Hannah Ridge at Feathergrass Filing No. 5, 6 and 7 Letter of Intent

Markup Summary

HANNAH RIDGE AT FEATHERGRASS FILING NO. 7

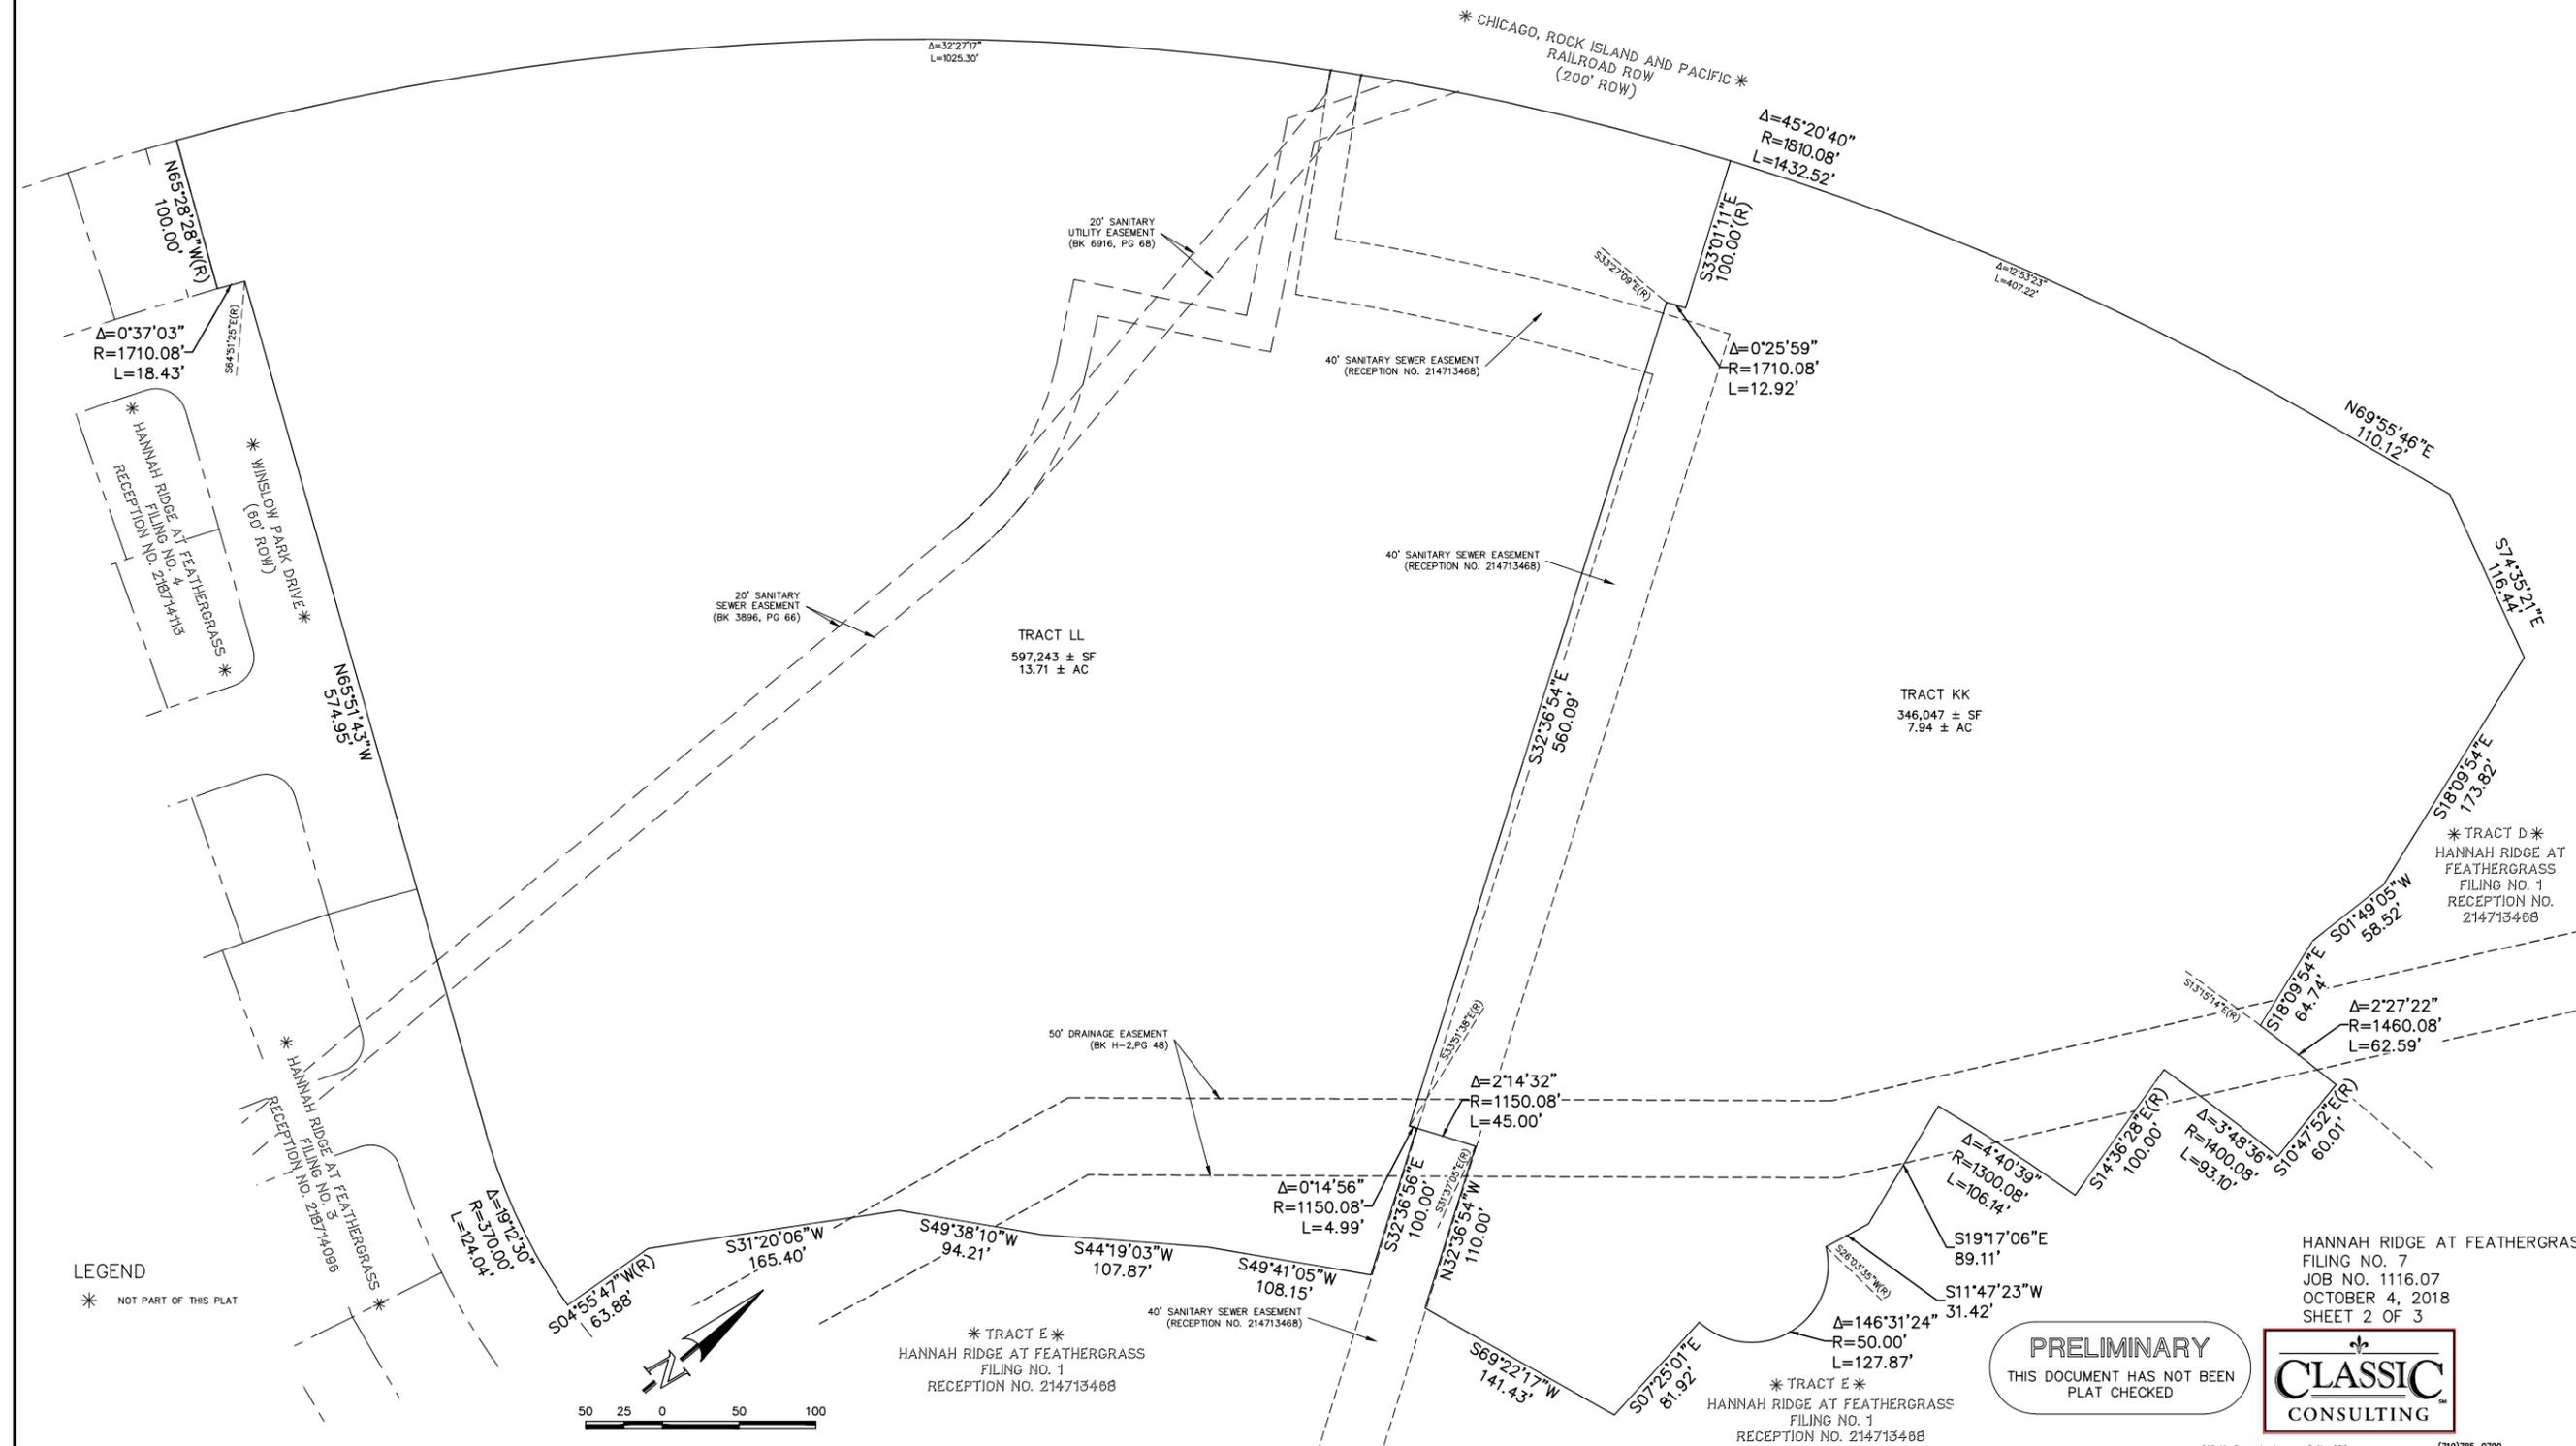
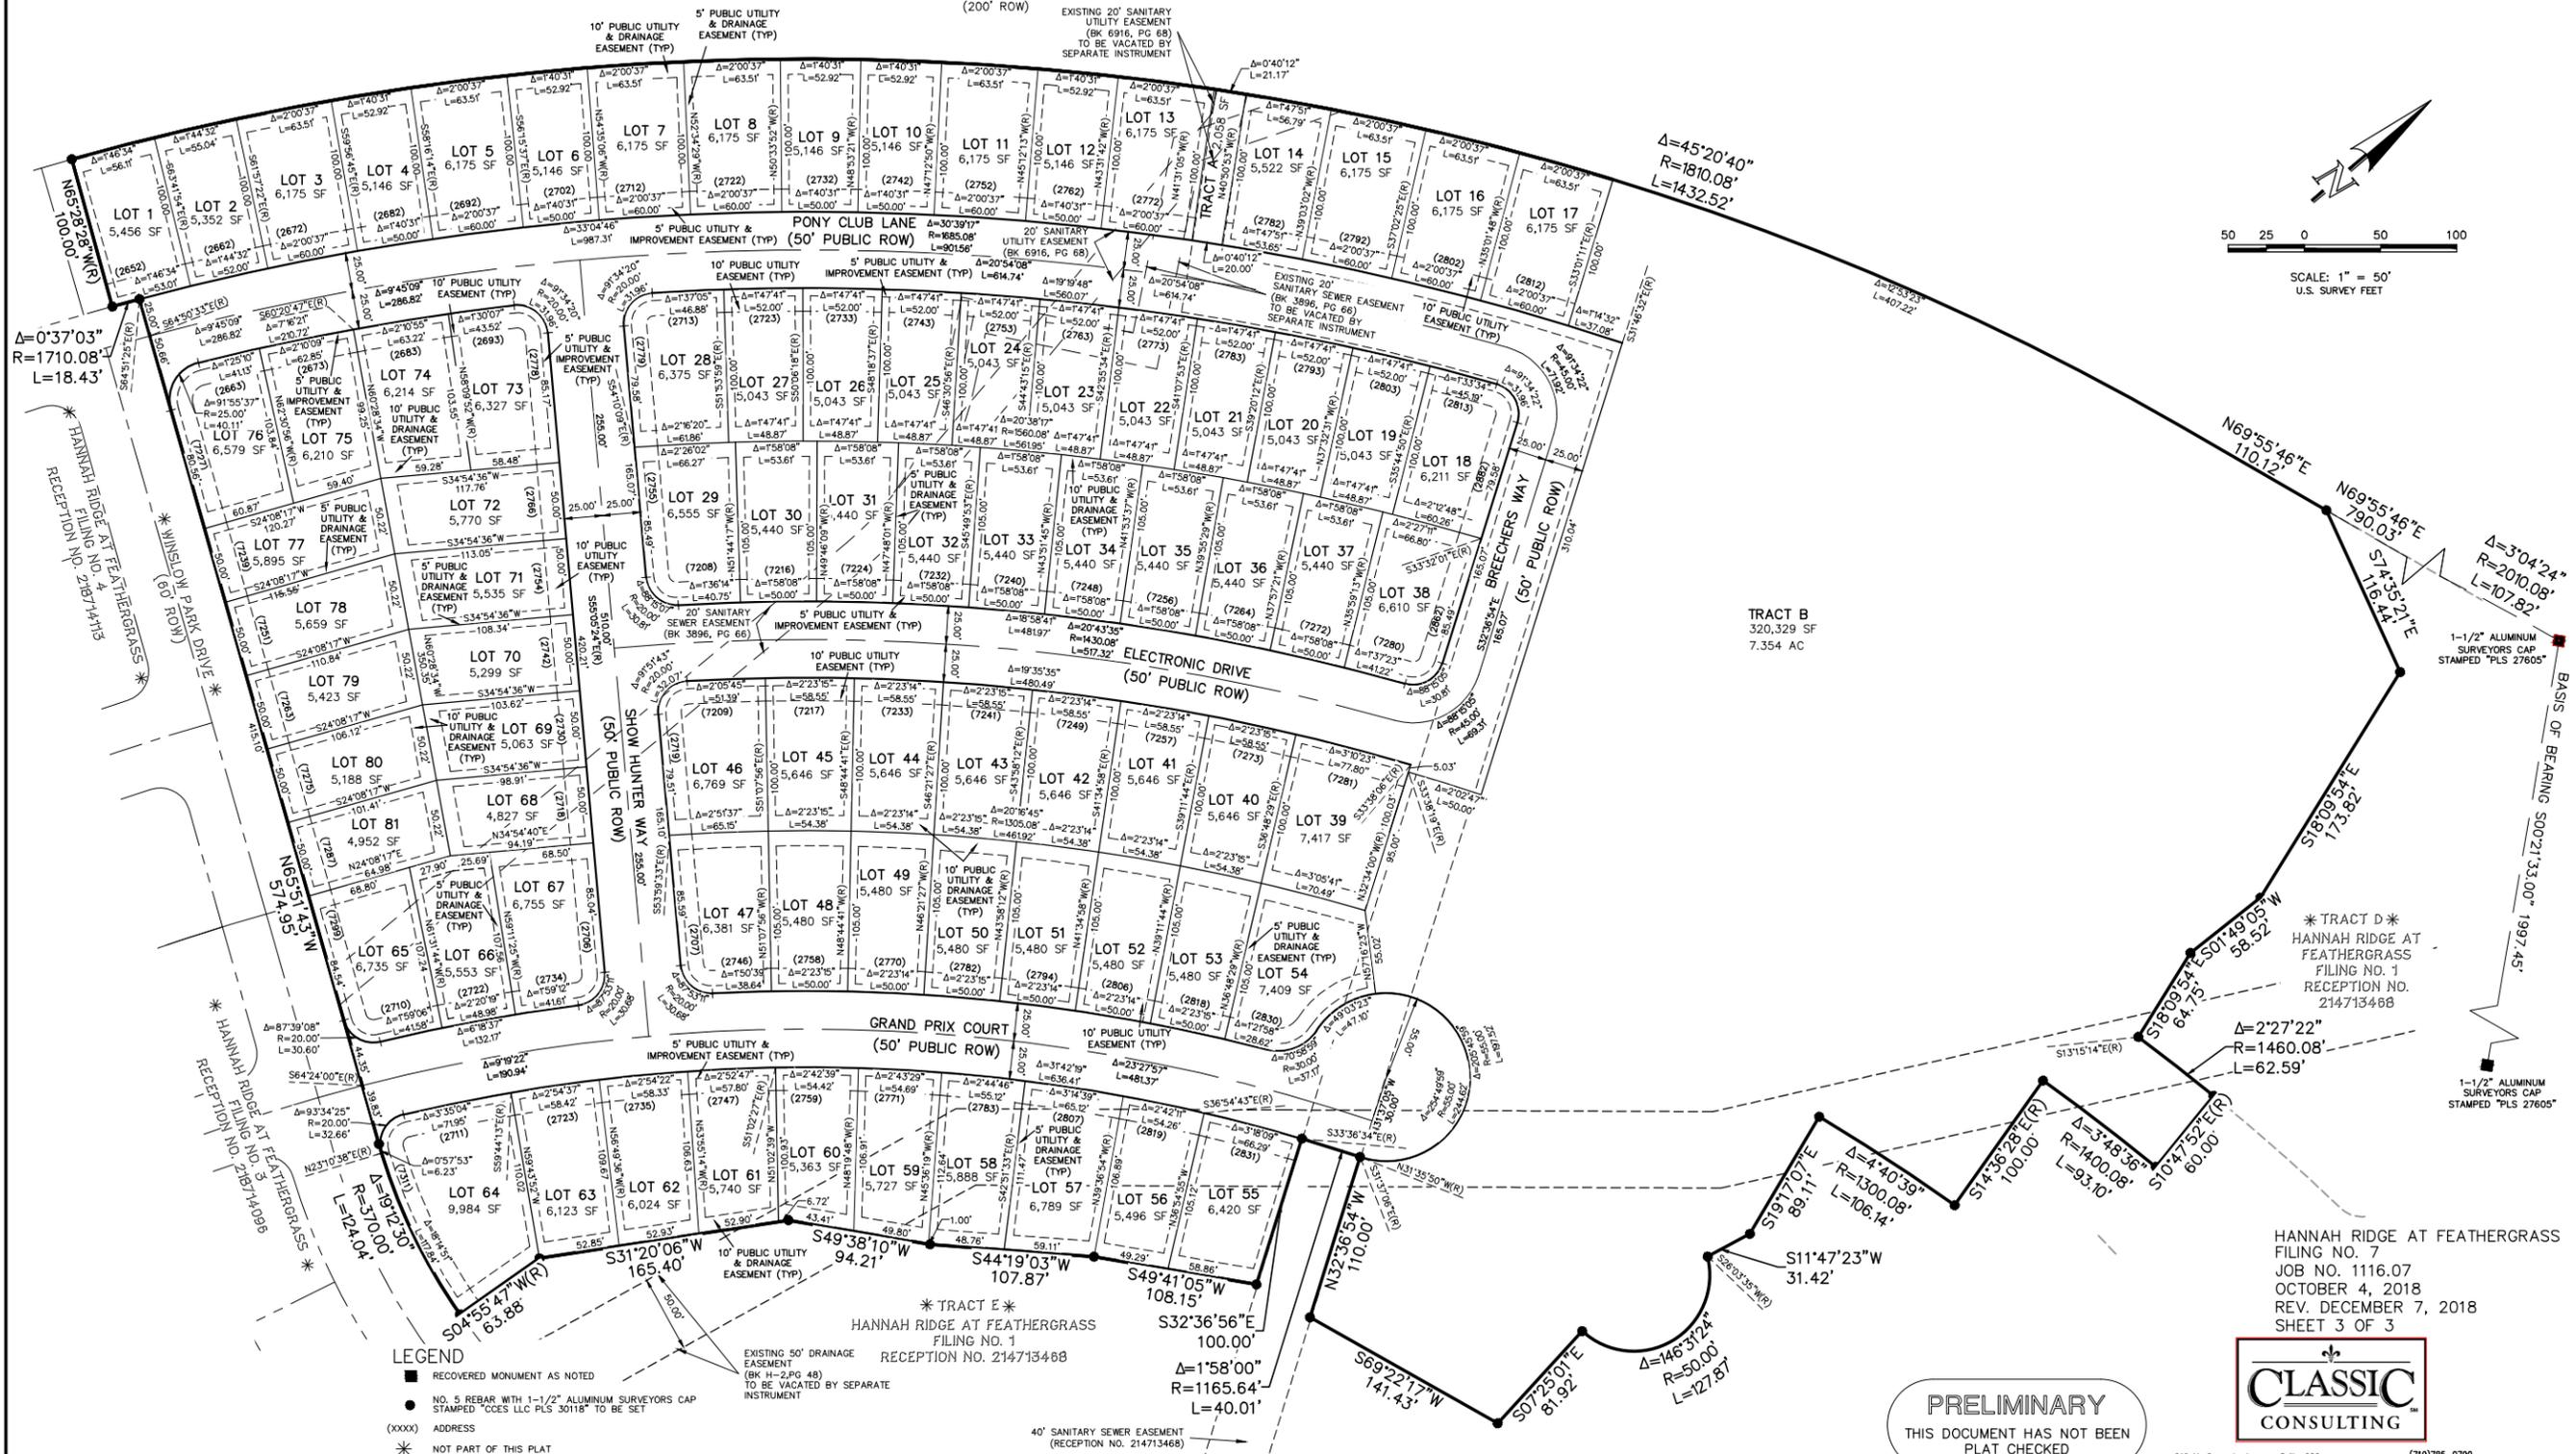
identify when the easement bisecting the plat -filing no 7 will go away.
